DELEGATED HOUSEHOLDER DECISION

Item No.	Report of the Head of Development Management and Building Control	
Address:	10 DOGHURST AVENUE HARLINGTON	
Development:	Change of use from a prayer room to a habitable space (retrospective).	
LBH Ref Nos:	58207/APP/2023/3460	
Drawing Nos:	01 02 - Proposed Elevations 03 - Proposed Floor and Roof Plan	
Date Plans received:	30-11-23	Date(s) of Amendments(s):
Date Application valid	30-11-23

Scale	1:50
m	0 0.5 1 1.5 2 2.5
Client:	Zeeshan
Property Address:	10 Doghurst ave, Hayes, UB3 5BJ
Job Number:	Dwg: 883 02
Scale:	1/50 @A3

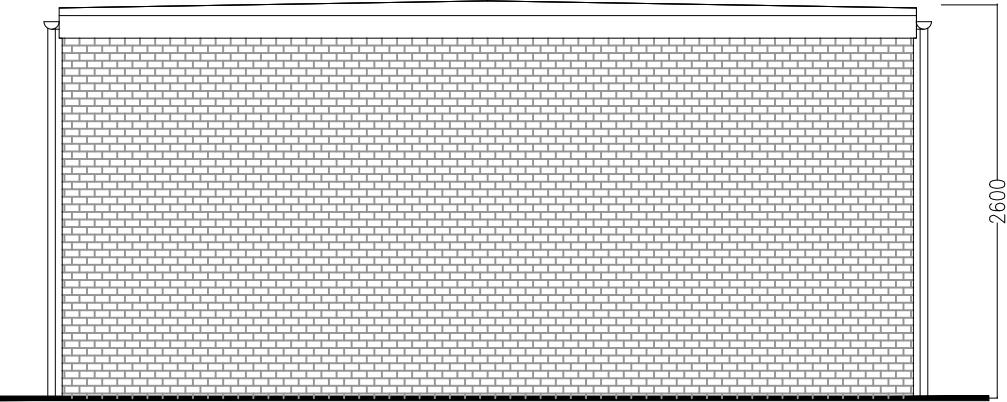
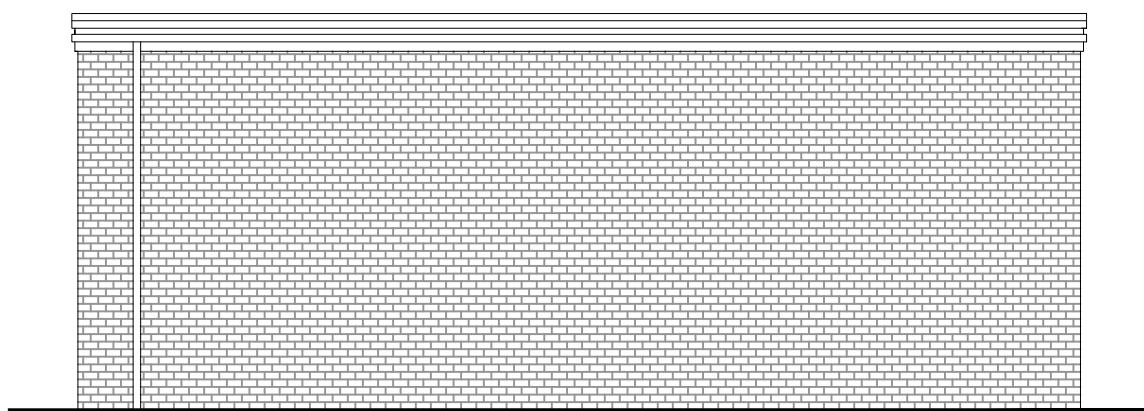
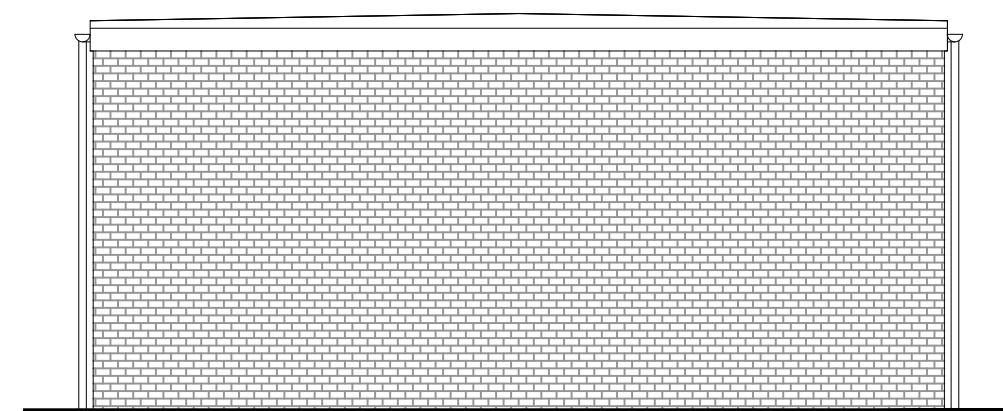
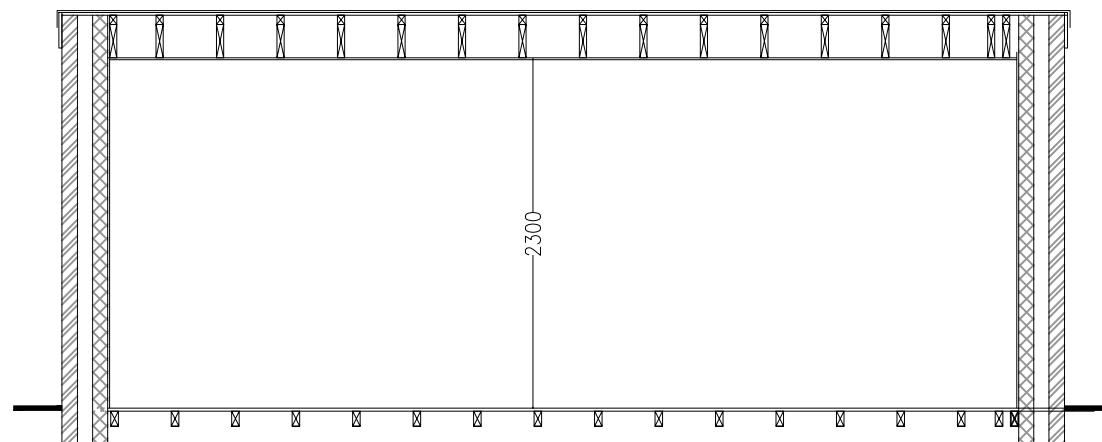
In this case, the submitted floor plan indicates an internal floor area of 37.3 square metres which would meet the the standards set out above. There are two windows on the front elevation along with the entrance door. These windows are overlooked by 10 Doghurst Avenue and a designated space for private amenity has not been provided. The new dwelling overlooks the amenity area of 10 Doghurst Avenue. By the nature of the design, as explained above, this would compromise the living conditions of both existing and future occupiers.
